**From:** Frances Stevenson [REDACTED]  
**Sent:** 28 September 2026 11:34  
**To:** Botley West Solar Farm  
**Subject:** Botley West Solar Farm: Community Food Growing

### Botley West Solar Farm: Community Food Growing

In response to your letter of 4 September 2026 giving Interested Parties the opportunity to comment on the Applicant's most recent submissions, I am writing regarding the Applicant's proposal for community food growing on 30 ha of land in Bladon, West Oxfordshire.

**Illustrative Masterplan**  
**Figure 2.2A**  
 Central Site Area 1 of 4

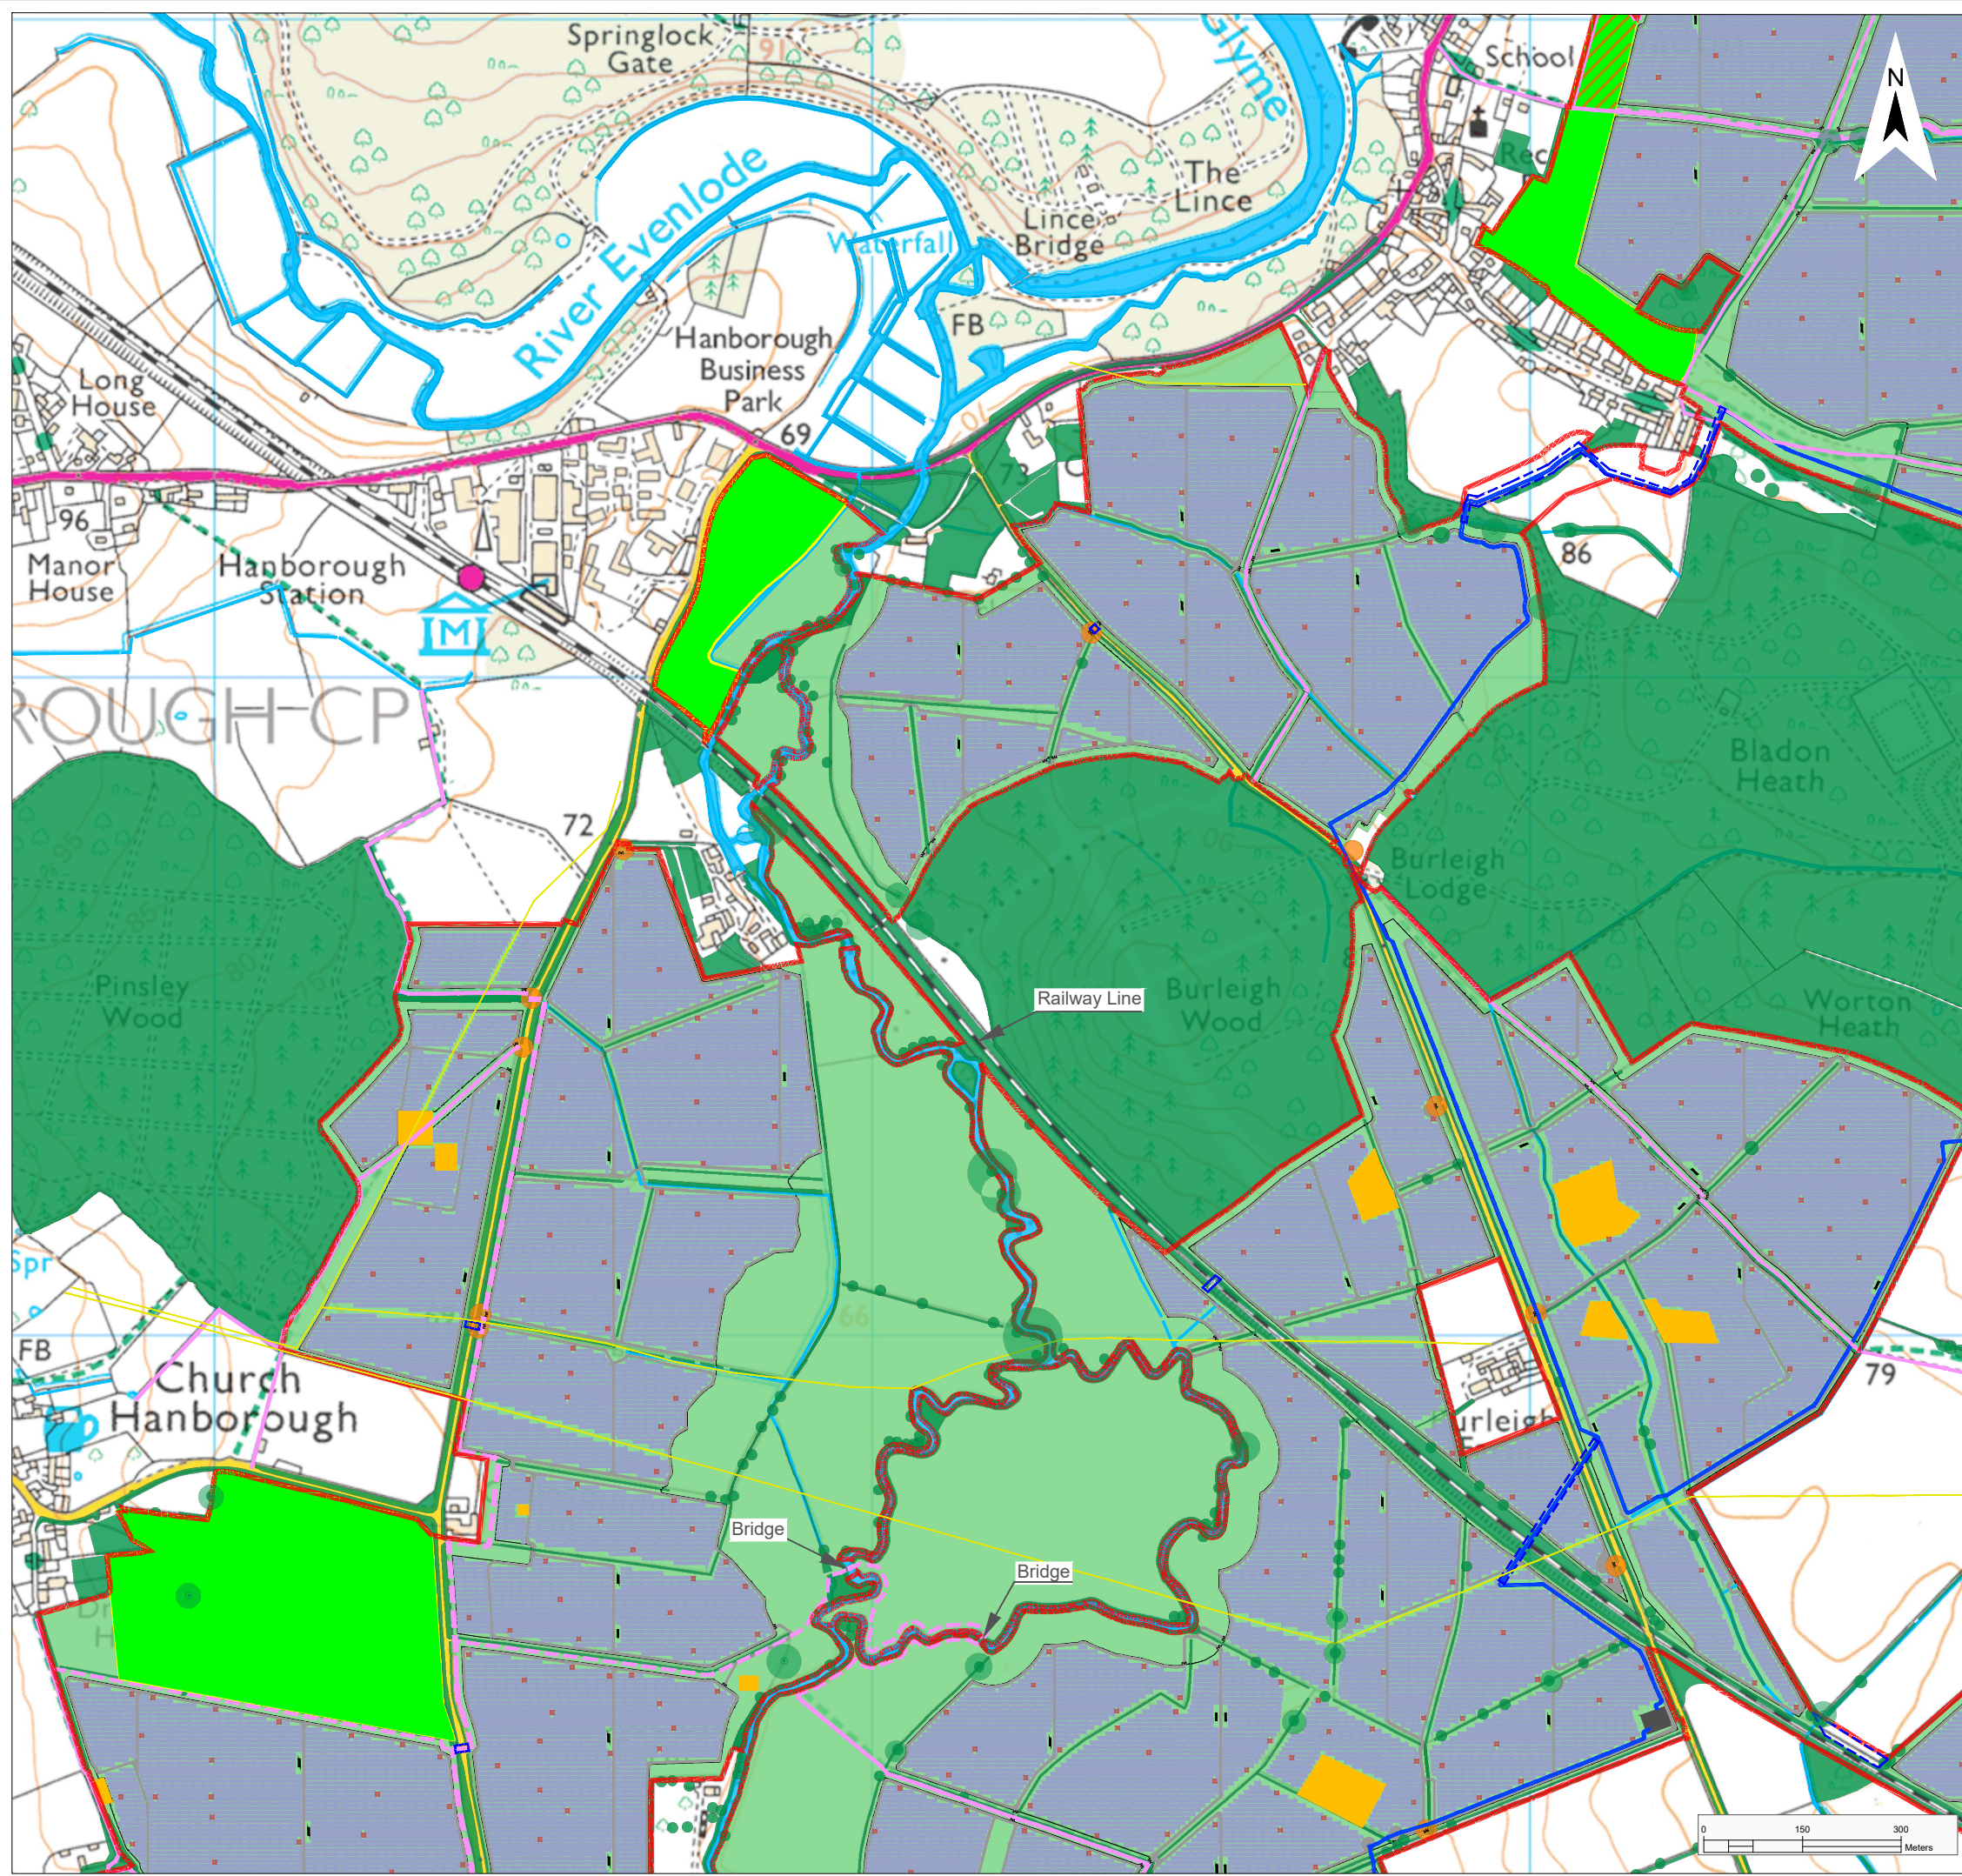
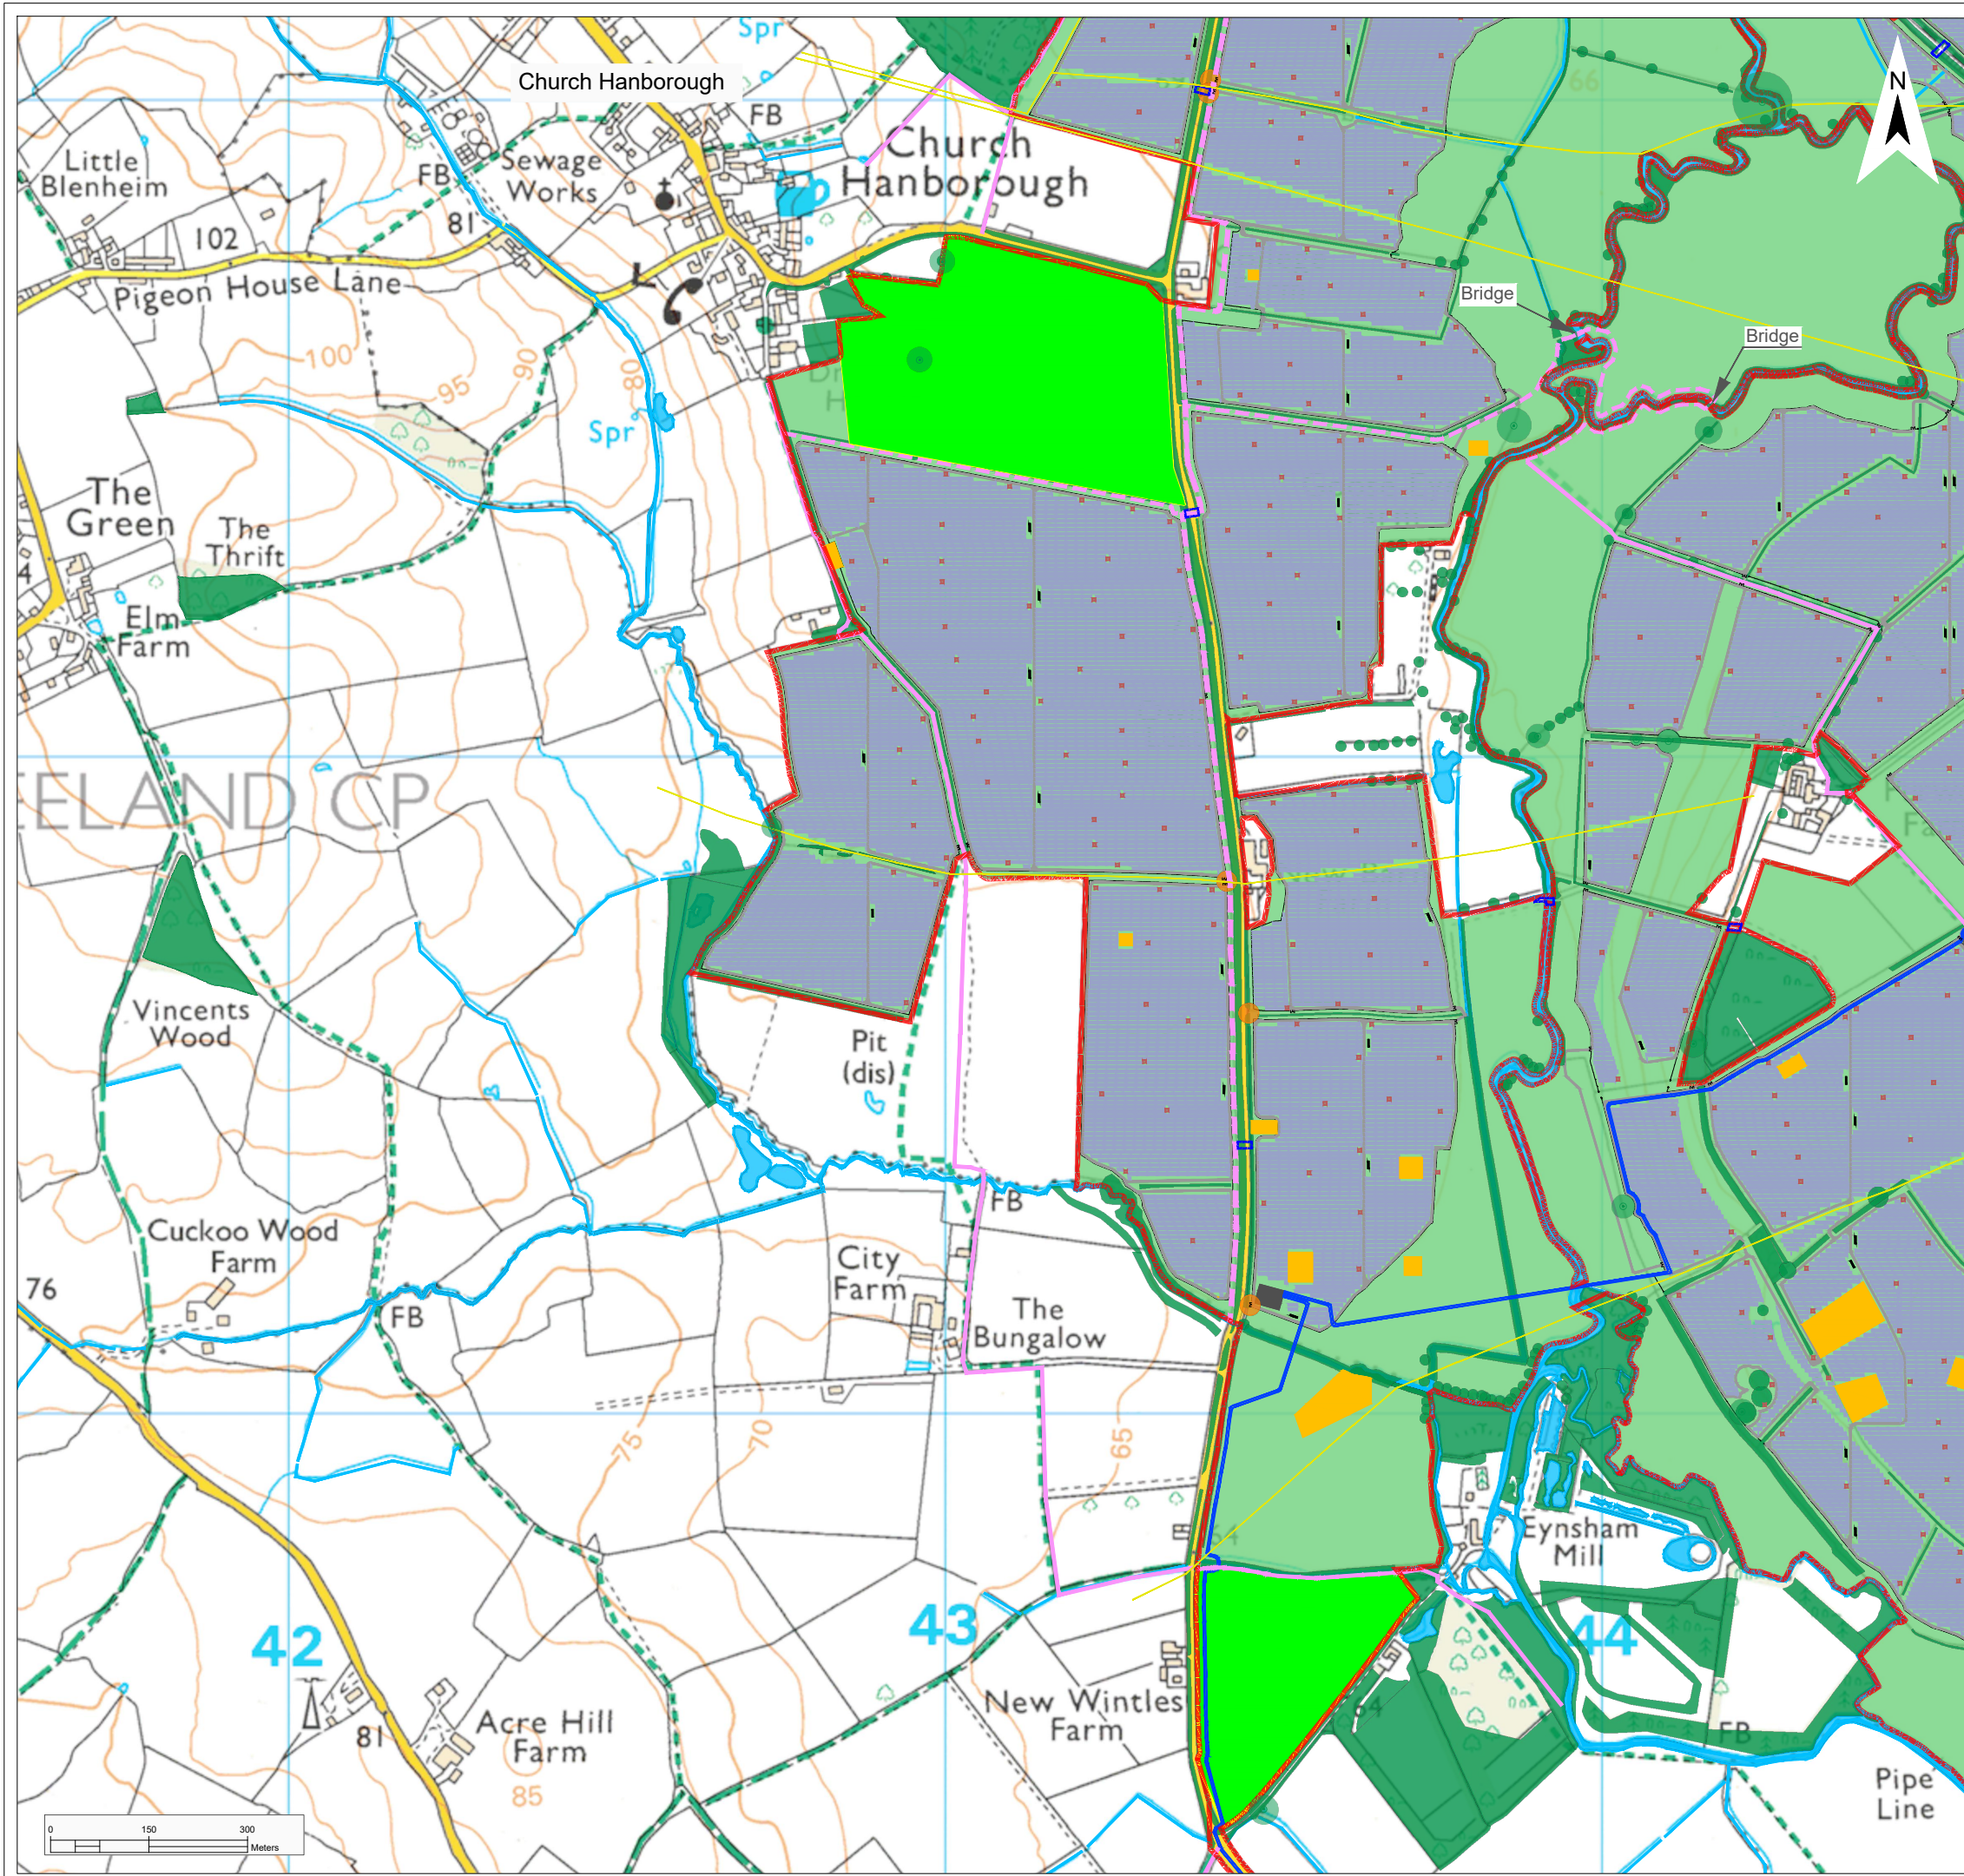
- Has not explained the interest in community food growing adequately or correctly.
- Has not explained how suitable access will be provided for the proposed food growing site in Bladon.
- Has not explained how the proposed food growing site in Bladon would be protected from inappropriate structures or how compliance would be guaranteed. (This is especially concerning because the site lies in the setting of the Blenheim World Heritage Site within sight of the Palace and grounds.)

I would also like to mention that the Applicant's Illustrative Masterplan (C1118 - Response to Secretary of State Consultation 1 - 6.4 ES - Figures 2.1a - 2.4c - Illustrative Masterplan - Rev 5) does not enable Interested Parties to distinguish between 'New planting/areas for enhancement' and 'Land available for community food growing area' because of the choice of colours used. We cannot tell whether changes have been made or what they might be.
